DECISION DELEGATED TO HEAD OF PLANNING

Application No: H16-0782-26 **Applicant:** Eastfield Guesthouse Ltd

Proposal: Change of use from Residential (C3) to Hotel (C1) - Approved under H16-0227-24. Modification of Condition 2 to allow amendments to previously approved plans

Location: 78 Pinchbeck Road Spalding

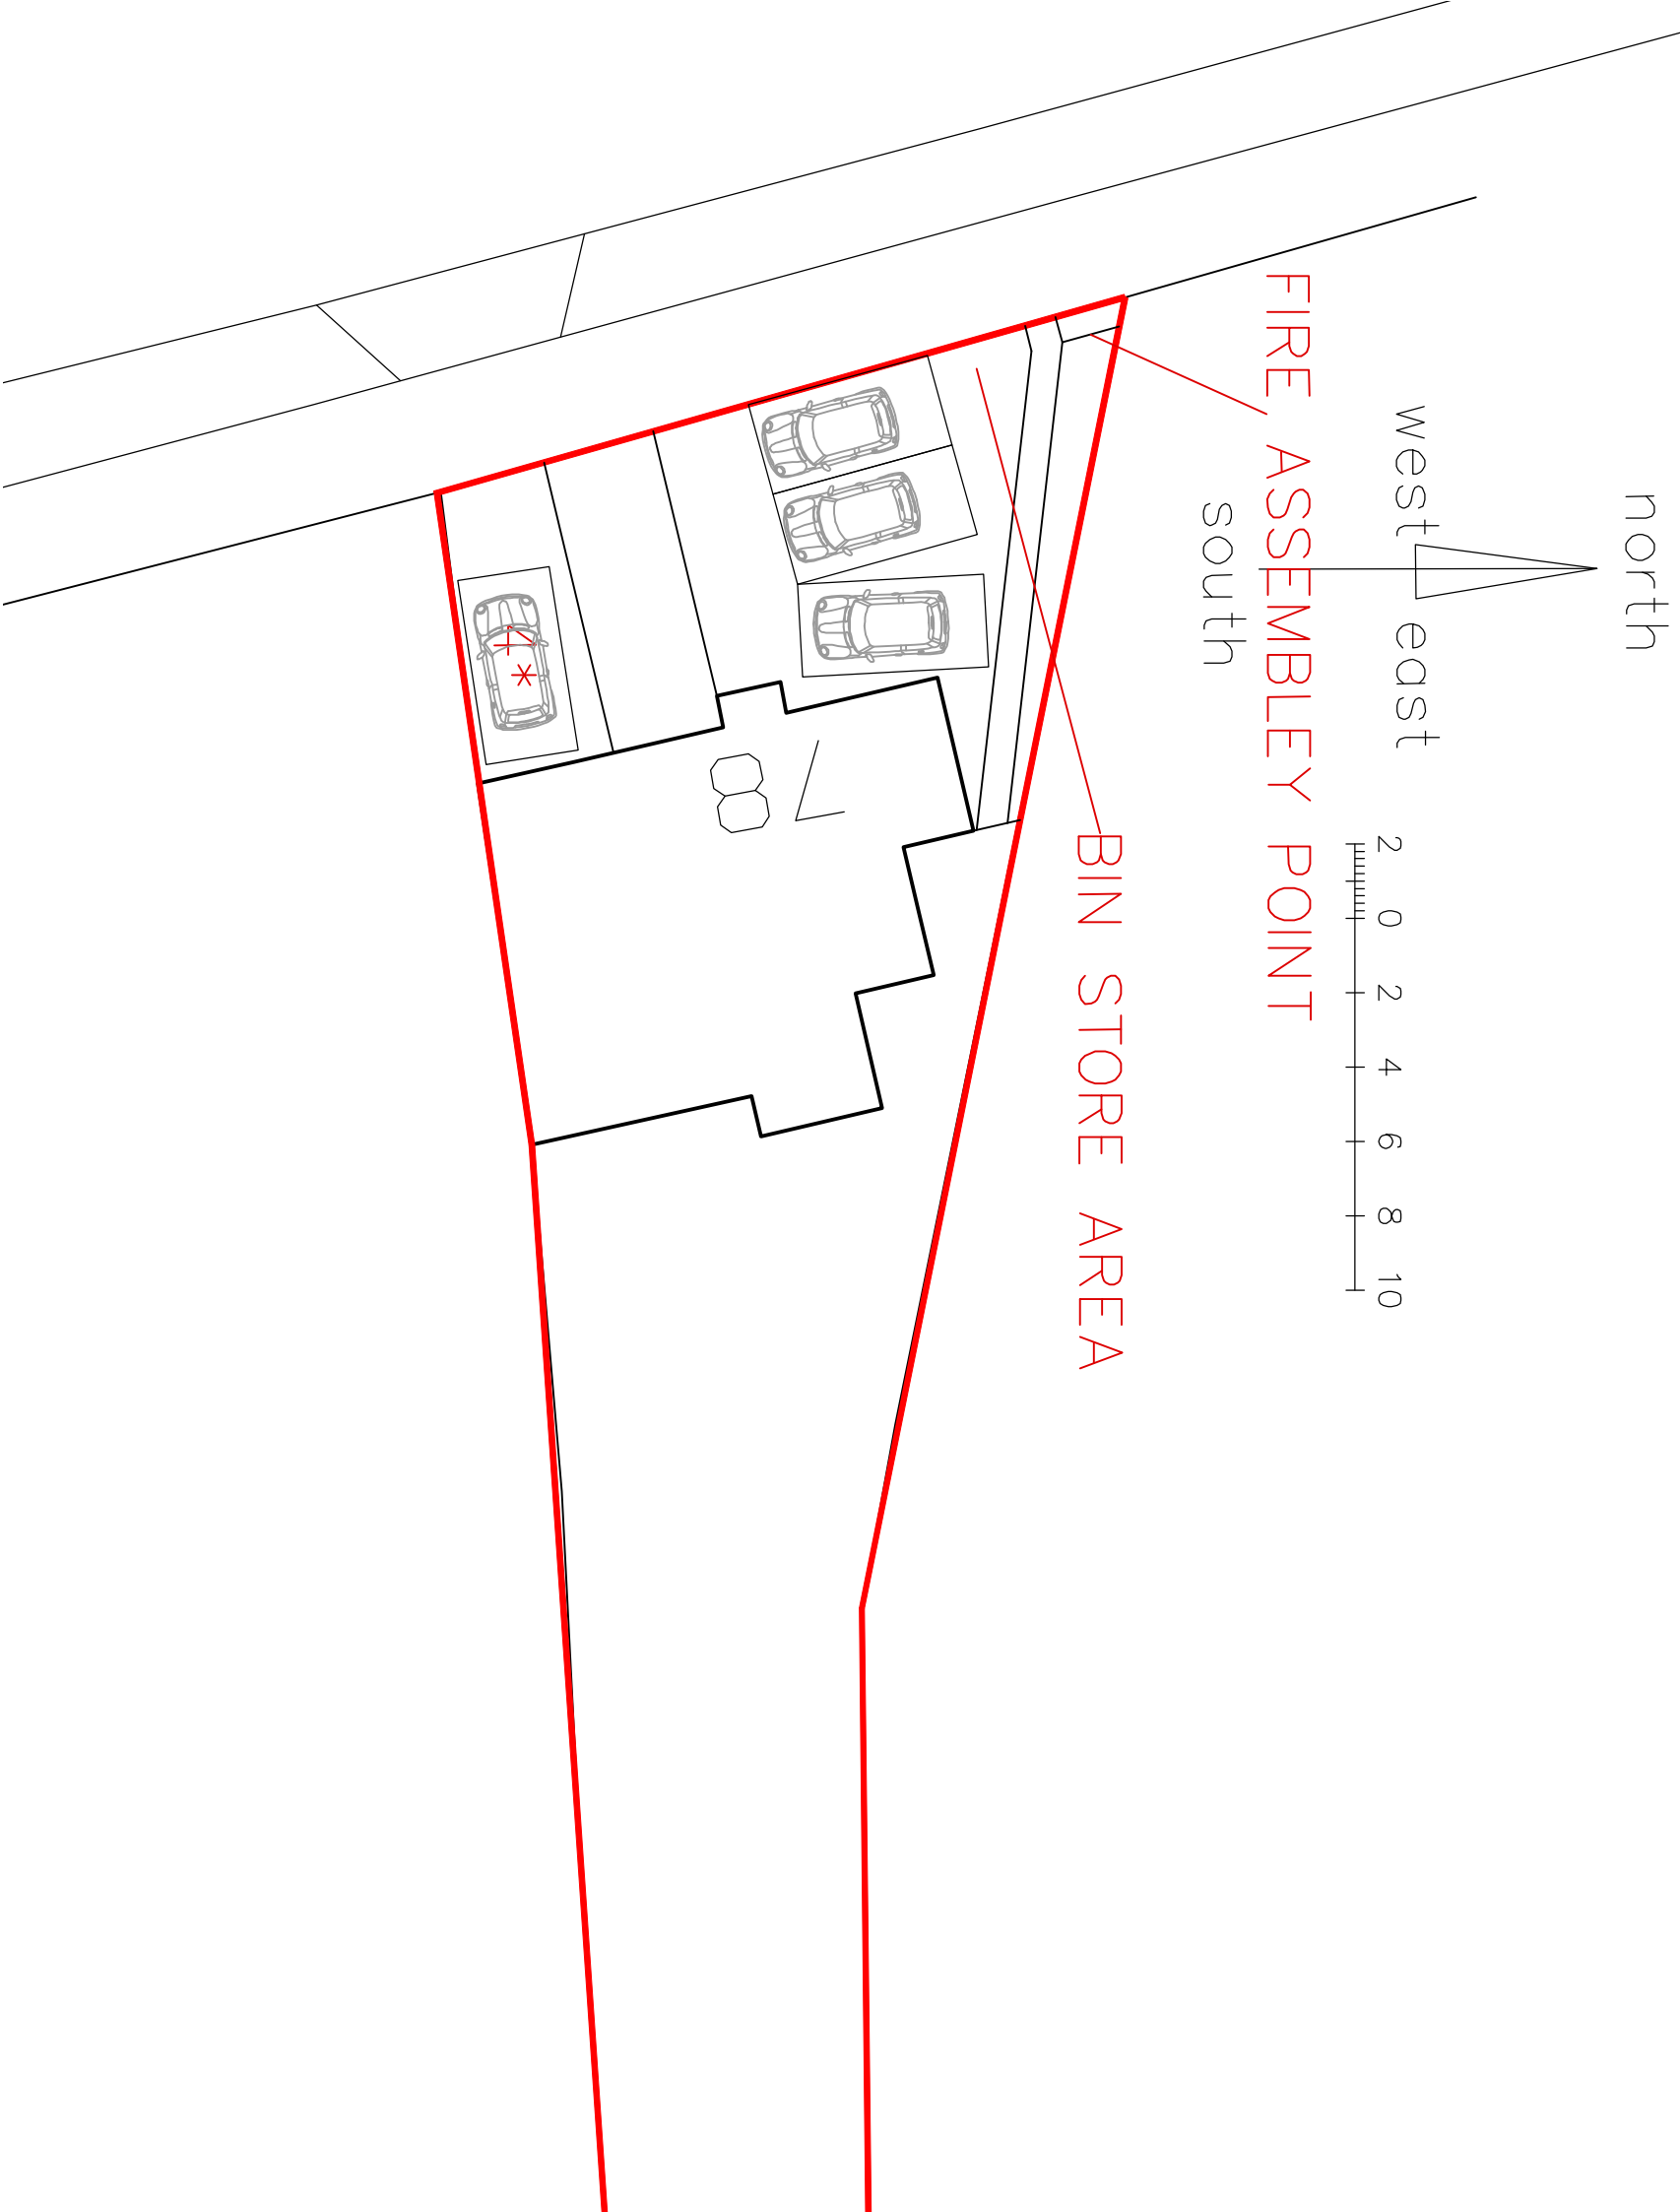
The Local Highway Authority notes that the application would increase the hotel accommodation from five to six letting rooms while retaining four parking spaces. Parking provision was queried during the original application but was not resolved before determination. The applicant states that the car park has been monitored since November 2024, with only three customer vehicles recorded in total and the car park never fully occupied. However, no monitoring records, methodology, hotel occupancy data, or information on staff parking have been provided to substantiate this claim. Please therefore provide:

A dimensioned layout demonstrating that four spaces can be independently accessed and exited with suitable manoeuvring space.

Confirmation of arrangements for guest, staff, servicing, and drop-off parking.

The monitoring records and methodology, including hotel occupancy and maximum simultaneous parking demand.

Details of secure cycle parking.

Whilst the comments of the Highway Authority are noted, the addition of a single bedroom would not significantly alter the highway impacts of development. Whilst anecdotal, the evidence provided by the Applicant shows that number of vehicles which have used the site since November 2024 is

three. This evidences a lack of need for additional parking, despite the additional bedroom, and the lack of overall impacts emerging from the development. The existing vehicle crossing was deemed acceptable under the previous application, and it is not considered that an additional bedroom would augment these considerations.

The site is readily accessible via sustainable modes of transport, with a bus stop almost immediately outside of the property's entrance, as well as the bus and train stations being within a reasonable walking distance (as per the definition in the Manual for Streets). There is therefore a reduced need for additional vehicle parking.

Whilst no dedicated cycle storage facilities have been shown on the plans, there is a storage area shown on the floor plans. The Applicant has indicated that this could reasonably be used for cycle storage also.

Furthermore, due to the location of the development within Spalding, there are a number of public car park options which could reasonably be utilised by future guests at the hotel should additional parking provision be required.
